From: Martyn White
Sent: 19 October 2018 09:31
To: Planning.Responses
Subject: R/190/18/PL

R/190/18/PL

The proposal is for the demolition of 1 existing house and the erection of 2 new detached dwellings. The site adjoins another proposal for a new detached house, and is close to the Station Road (East Preston) Conservation Area.

Drawing Title:
ADDITIONAL DWELLINGS
BLOCK/ SITE PLAN

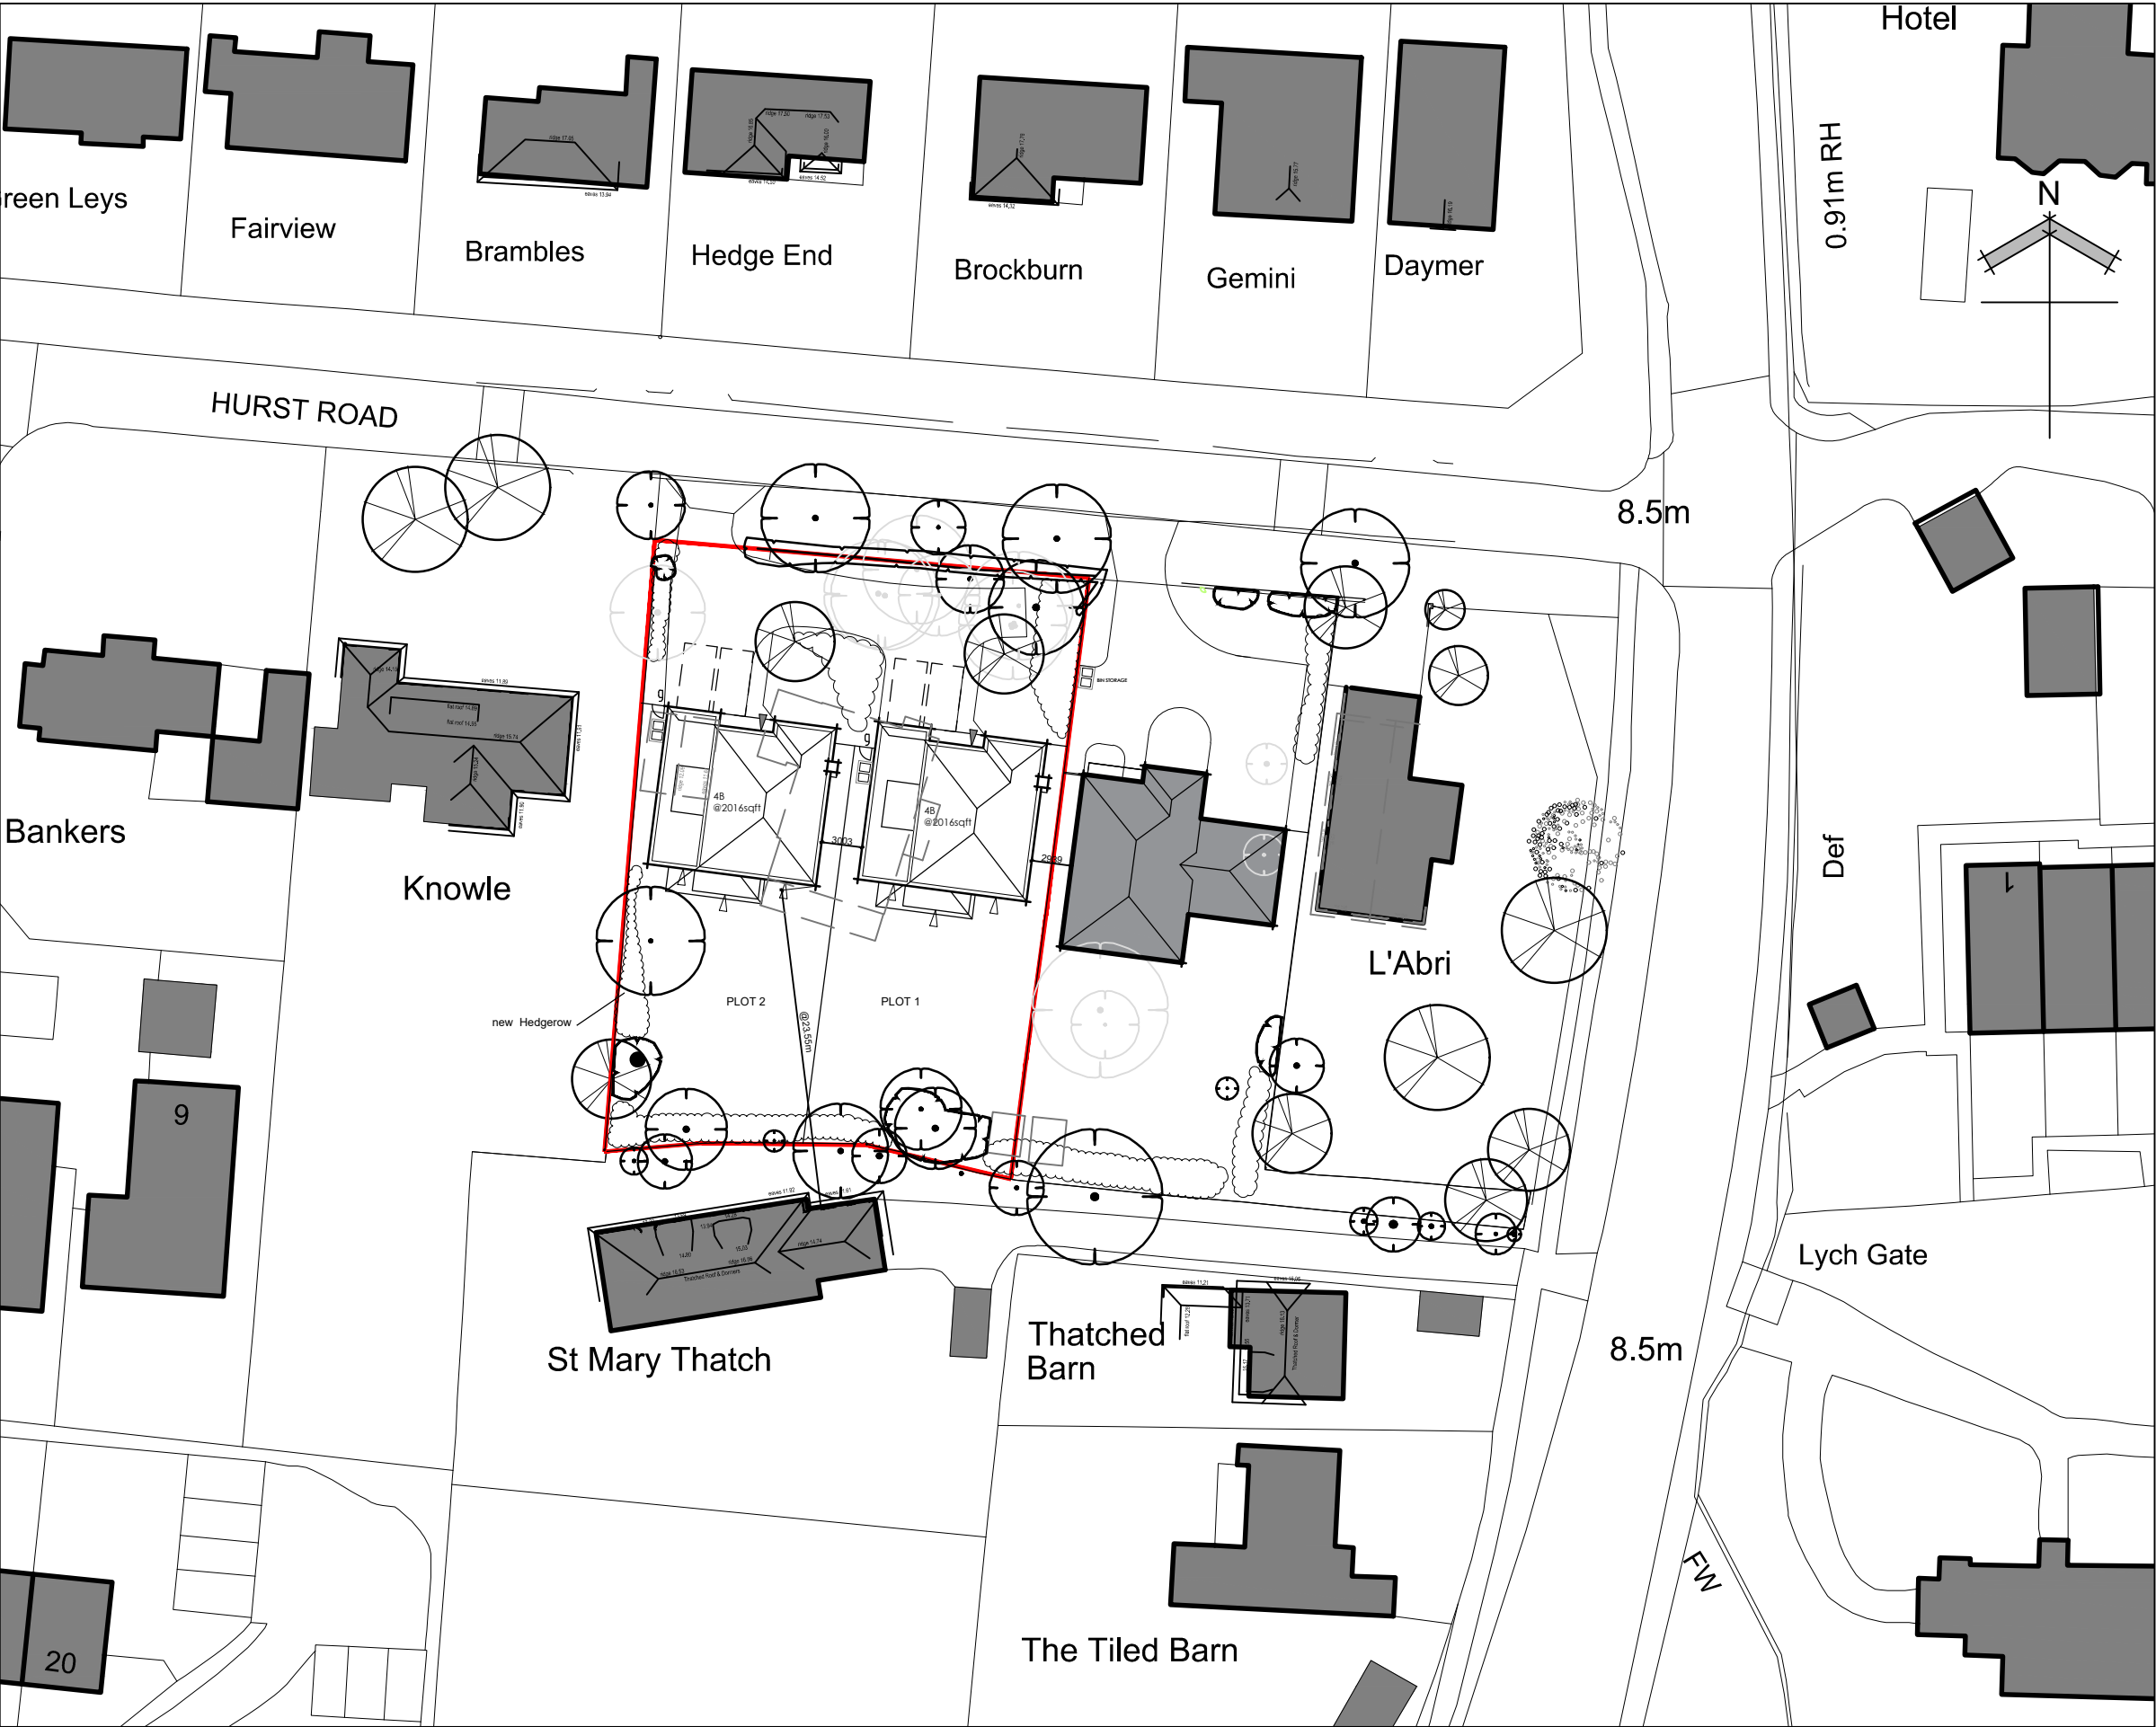
The position of the new dwellings is not considered to affect the conservation area, due to the presence of some intervening properties, which will in effect, have the result of screening them (even if to some extent).

Drawing Title:
ADDITIONAL DWELLING
PLOTS 1 & 2
ELEVATIONS

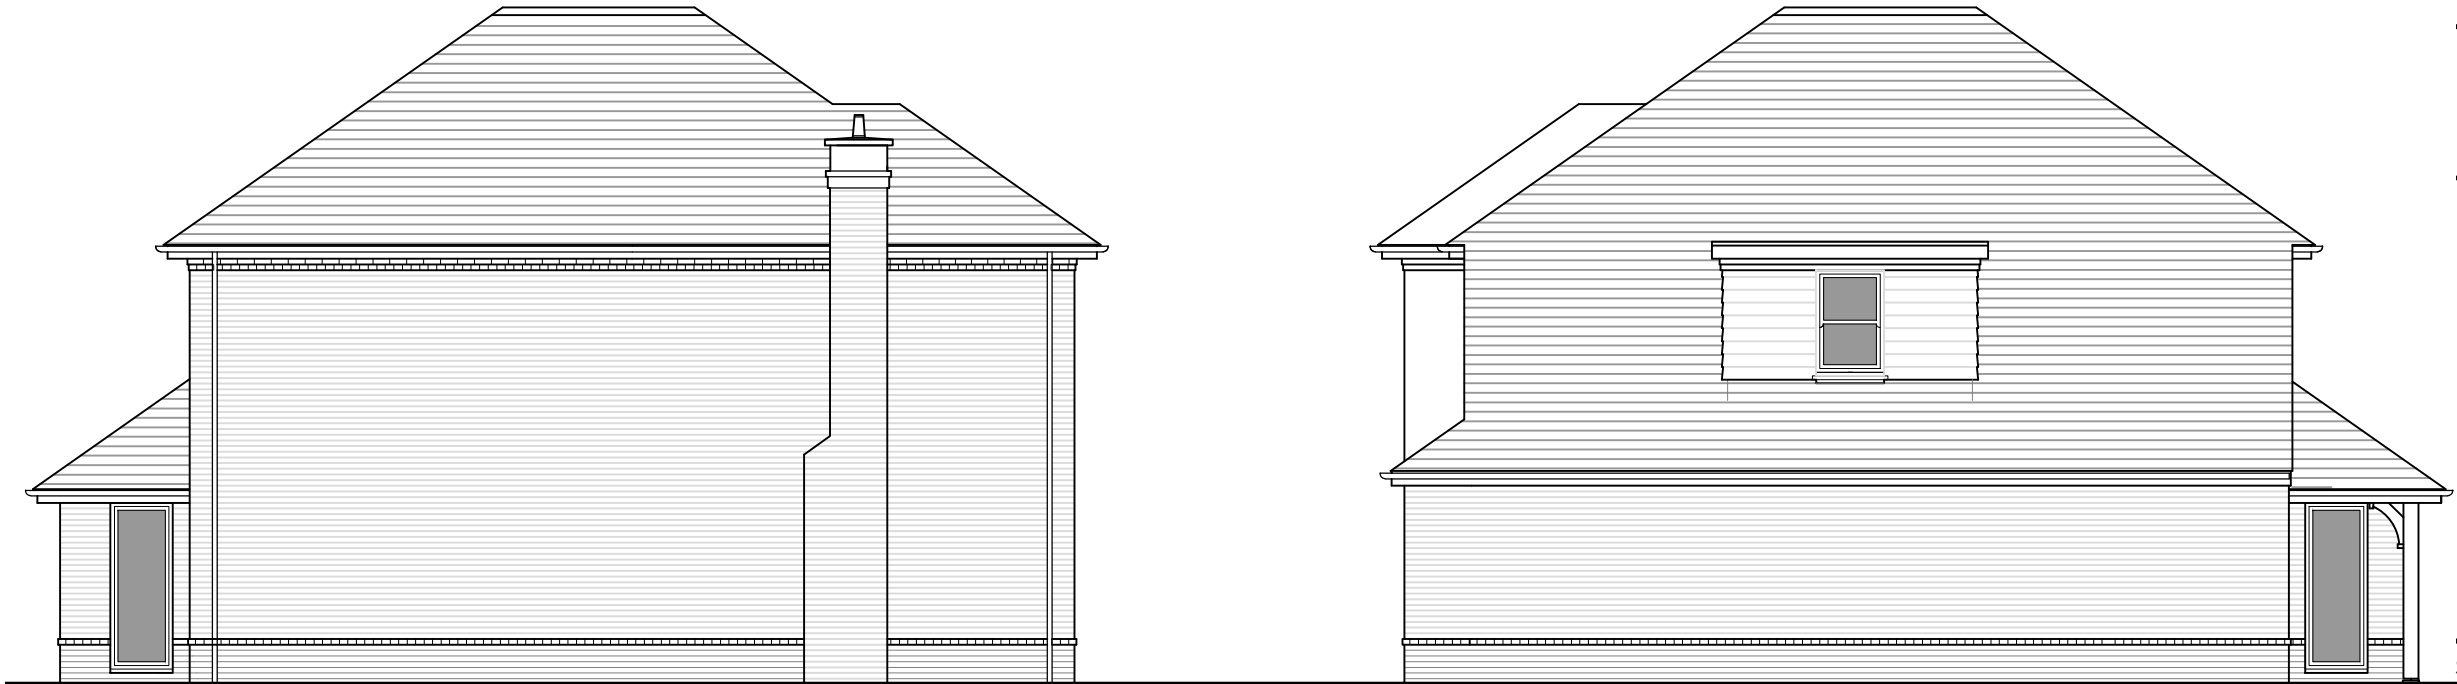
The design of the two dwellings is considered to be acceptable, subject to the quality of the materials and the window joinery to be used. Details of these should be submitted to the council by way of condition.
